Pony Tracks, Filing No. 2, MS-19-008

Please accept the following comments from El Paso County Public Health regarding the minor subdivision project referenced above:

SEPTIC SUITABILITY MAP
2030 OLD NORTH GATE ROAD
EL PASO COUNTY, CO.
FOR: MVE, INC.

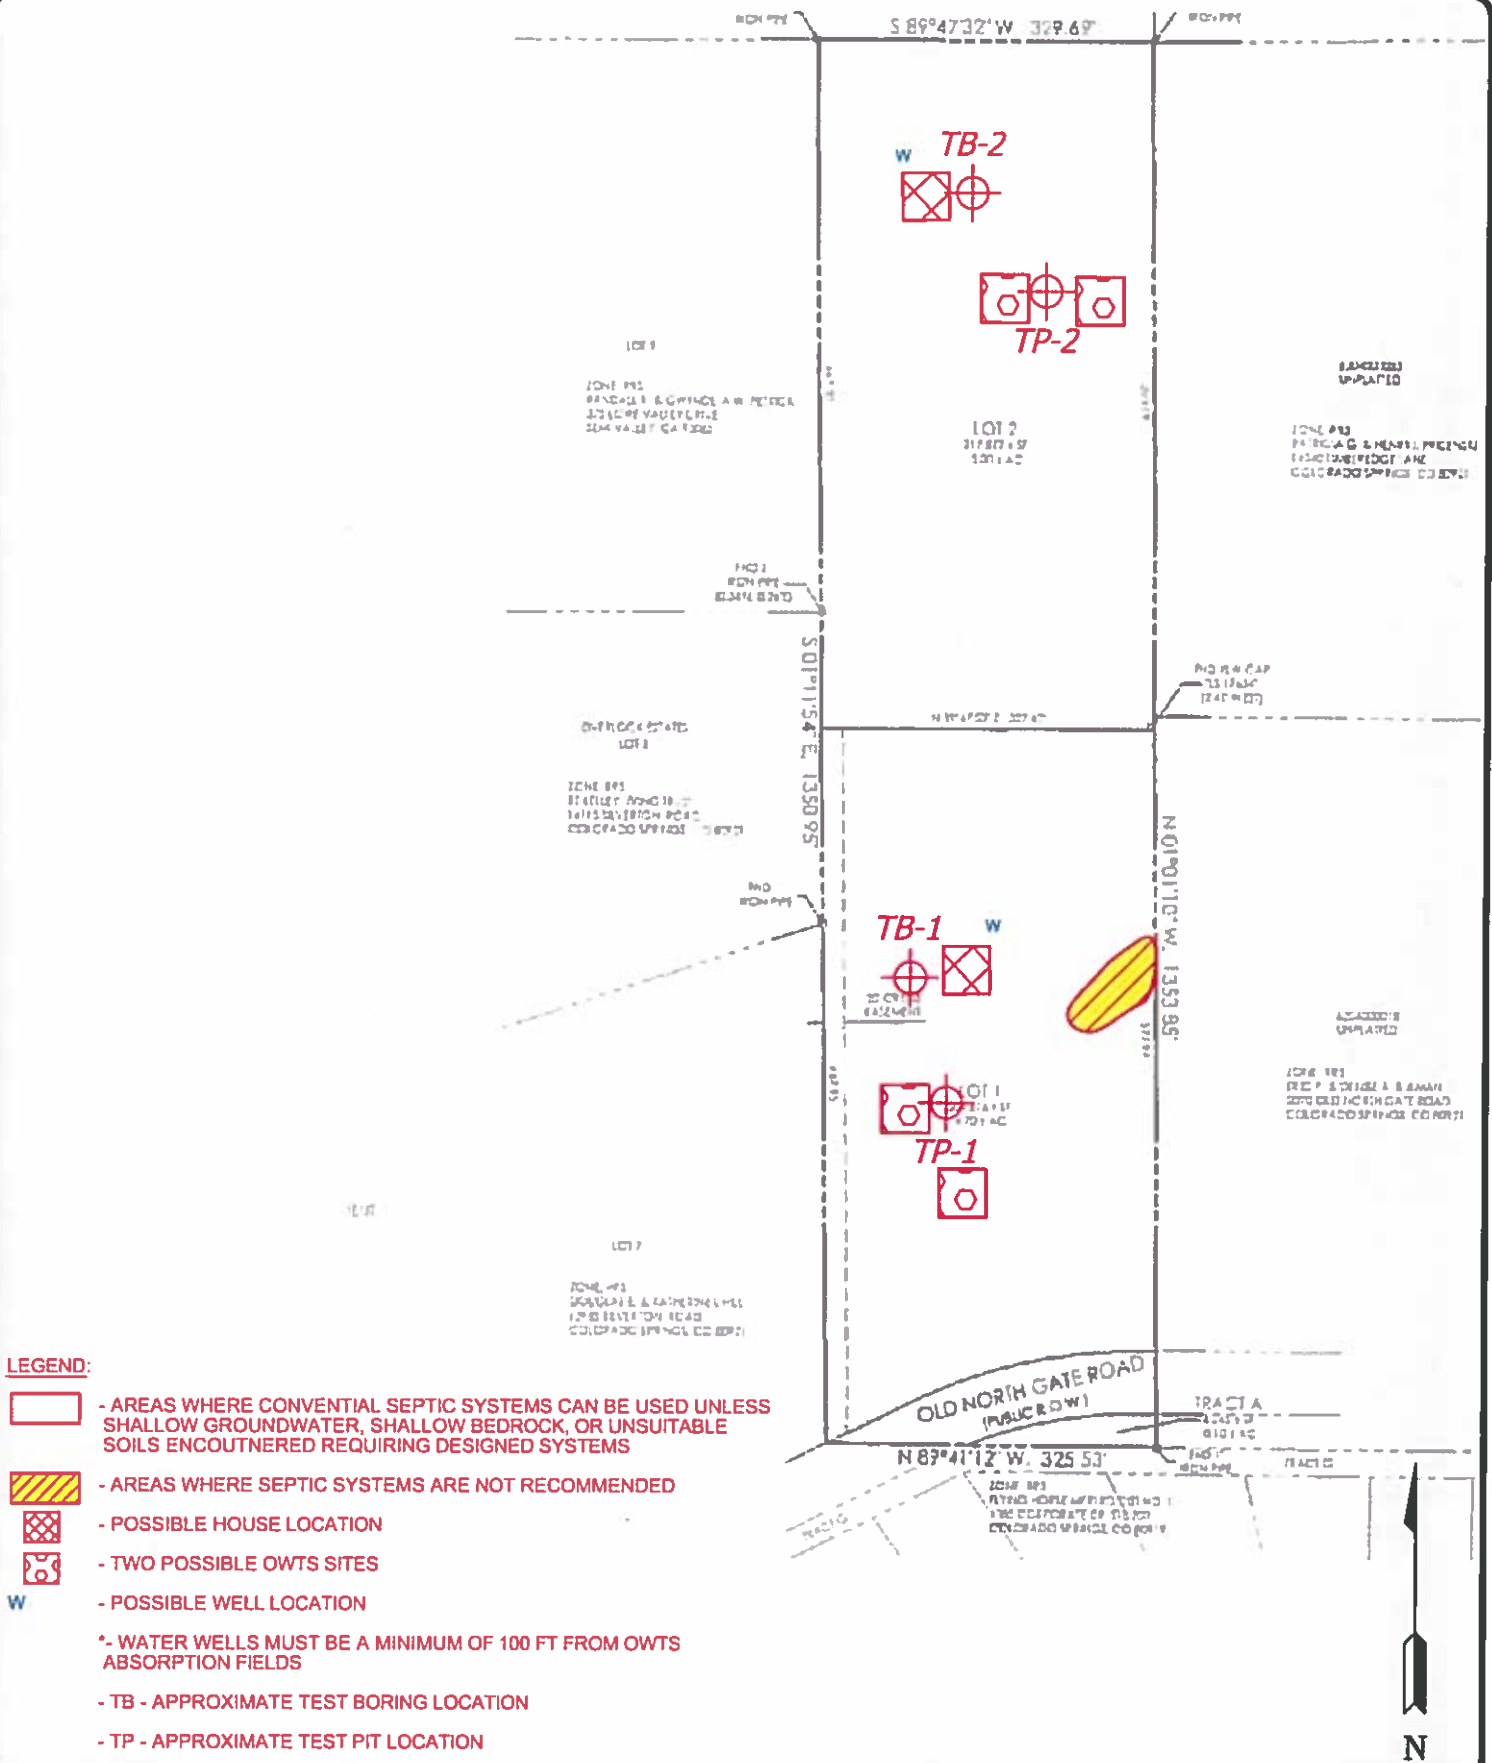
- **The proposed Lot #1 will contain an existing house with an onsite wastewater treatment system (OWTS) installed in 1959 and prior to OWTS permit requirements in El Paso County. The OWTS components must be located and contained entirely on Lot #1 and meet all the El Paso County Public Health OWTS minimum installation setbacks. There must be sufficient area on Lot #1 for repair or replacement of the OWTS if ever required in the future.**

The Entech Engineering, Inc., Soil, Geology, Geologic Hazard, and Wastewater Study for Pony Tracks Subdivision, Filing No. 2, 2030 Old North Gate Road, El Paso County, Colorado, indicated the existing house constructed in 1959 will be removed from Lot #1. If the house is removed, then the existing OWTS components must be abandoned per El Paso County Public Health OWTS Regulations.

- **The new Lot #2 wastewater service will use a new OWTS. The Entech Engineering, Inc., Soil, Geology, Geologic Hazard, and Wastewater Study for Pony Tracks Subdivision, Filing No. 2, 2030 Old North Gate Road, El Paso County, Colorado, indicated the soil is suitable for an OWTS installation. Full compliance with El Paso County Board of Health Regulations, Chapter 8, Onsite Wastewater Treatment System Regulations is required.**
- **Proposed Lot #2 will have an individual private well that must meet the minimum setback requirements from interior and surrounding OWTS components as required.**
